Application for a non-material amendment following a grant of planning permission.  
 Town and Country Planning Act 1990

TWO STOREY SIDE AND REAR EXTENSION  
TO EXISTING DETACHED DWELLING.

21/0263/HOU

NEW BATHROOM WINDOW TO SIDE ELEVATION.  
OBSCURED GLASS, OPENING LIGHT MIN. 1.7M  
ABOVE FLOOR LEVEL.

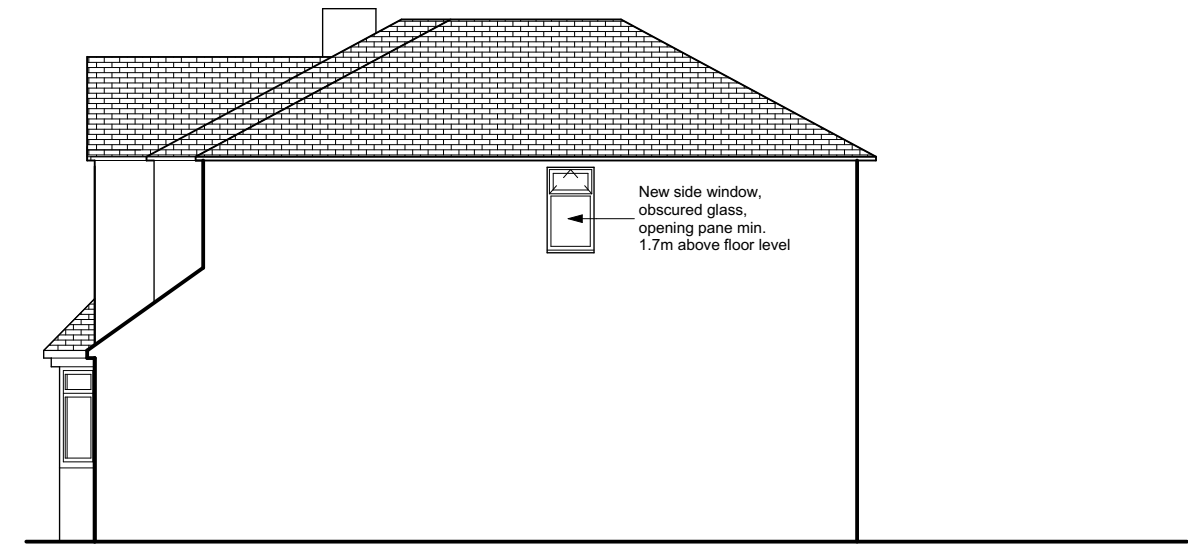
INTERNAL LAYOUT CHANGE SO BATHROOM WINDOW  
NOW REQUIRED.
